CITY OF ALBUQUERQUE

Re: **Santa Fe ⁴ at the Trails Unit II Grading and Drainage Plan**
Engineer's Stamp dated 7-12-06 (C9/D1B)
15

**TIERRA VISTA UNIT 2 at the TRAILS**  
**GRADING AND DRAINAGE PLAN**

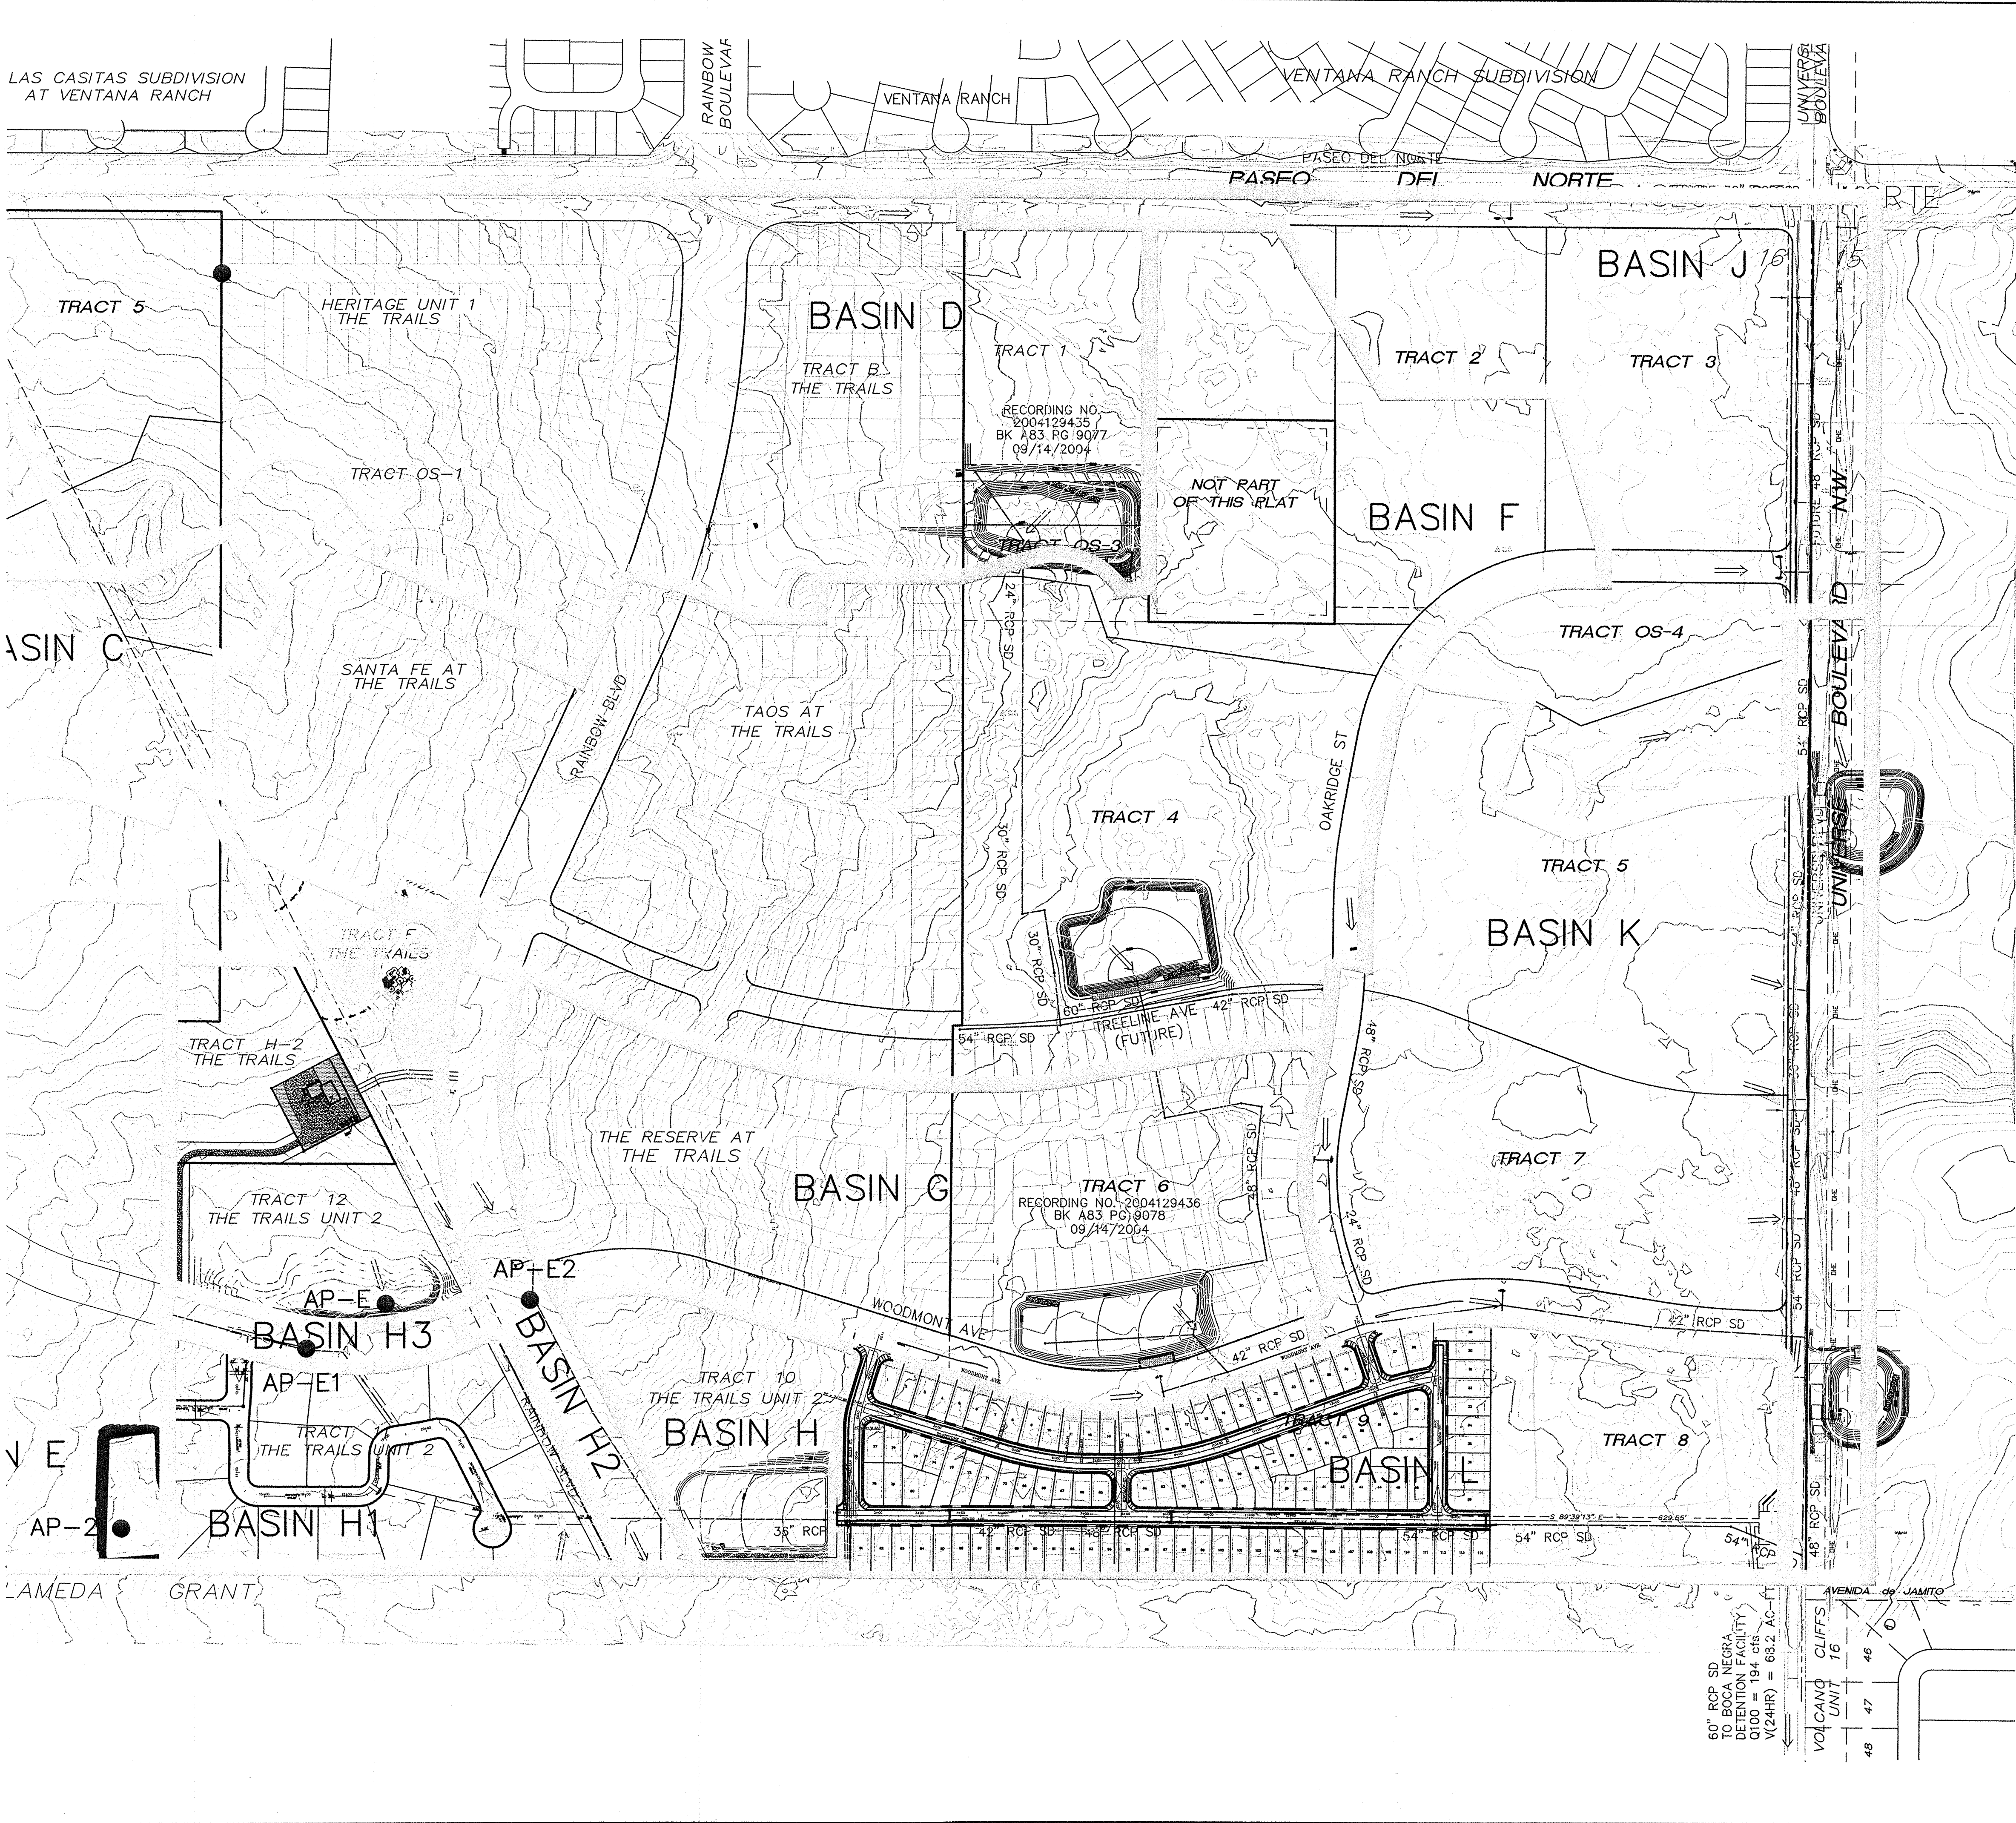
- Raising this site is creating a drop-off to the lot on the South (APS North West High School). Obtain permission from APS to change the grade of their property so that the grade of the APS property is a 3-1 taper up to this site or a grade acceptable to APS. Include a sign-off block on the plan.
